Rezoning Transportation Analysis

Petition Number: #2022-078

Date	Description
11-02-22	First Review (TM)

SHEET NUMBER RZ-01

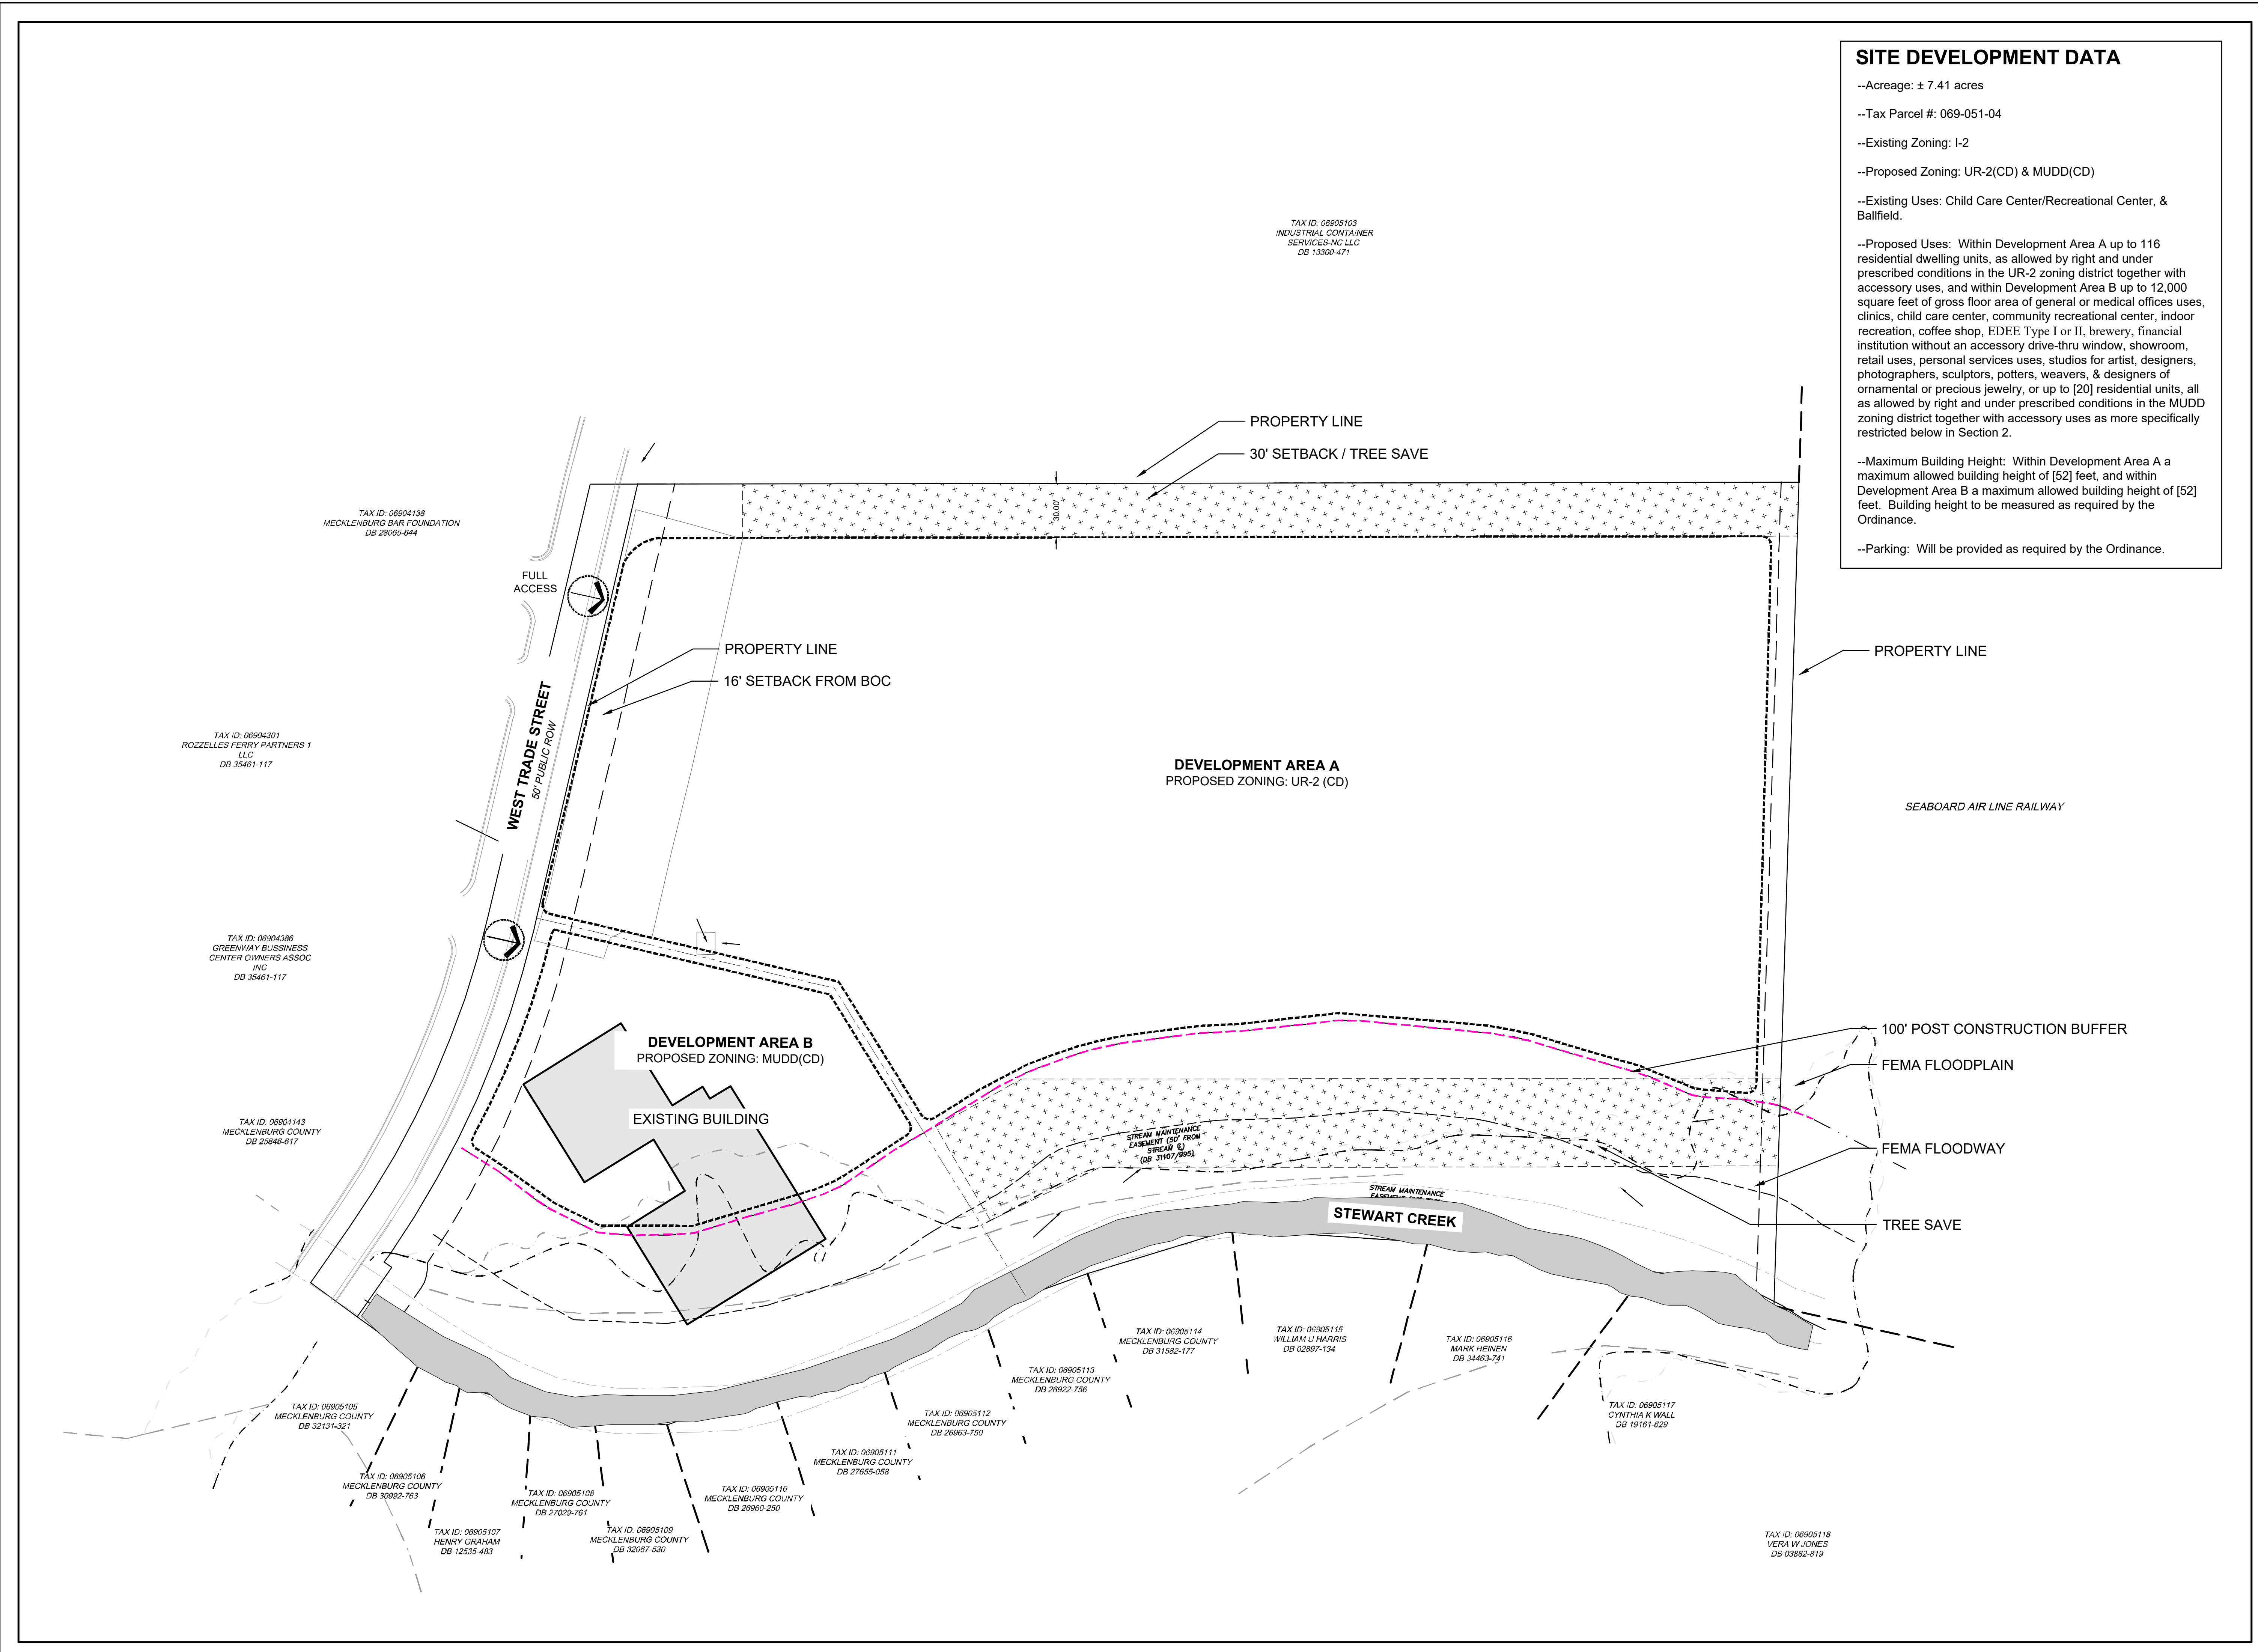
1. **Curblines:** The proposed zoning district has a setback measured from back of the existing or proposed future curblines.
 - a. **West Trade Street:** The future location of curb and gutter is measured at 17.5-feet from the centerline of the roadway to the BOC.

Label and dimension the curb and gutter from the centerline for each road on the site plan.

3. Revise site plan and conditional note(s) to commit to constructing the proposed internal private roadways to private road standard typical section standard per CLDSM 11.13. Site plan shall dimension from the centerline of the roadway and callout roadway typical per CLDSM. Add a conditional note committing to constructing all private streets to the standard of CLDSM 11.13.

4. Revise site plan to commit to construct an 8-foot planting strip and 8-foot sidewalk along the site frontage per Chapter 19. The site plan shall label and dimension both items from the back of future curb and gutter and road centerline.
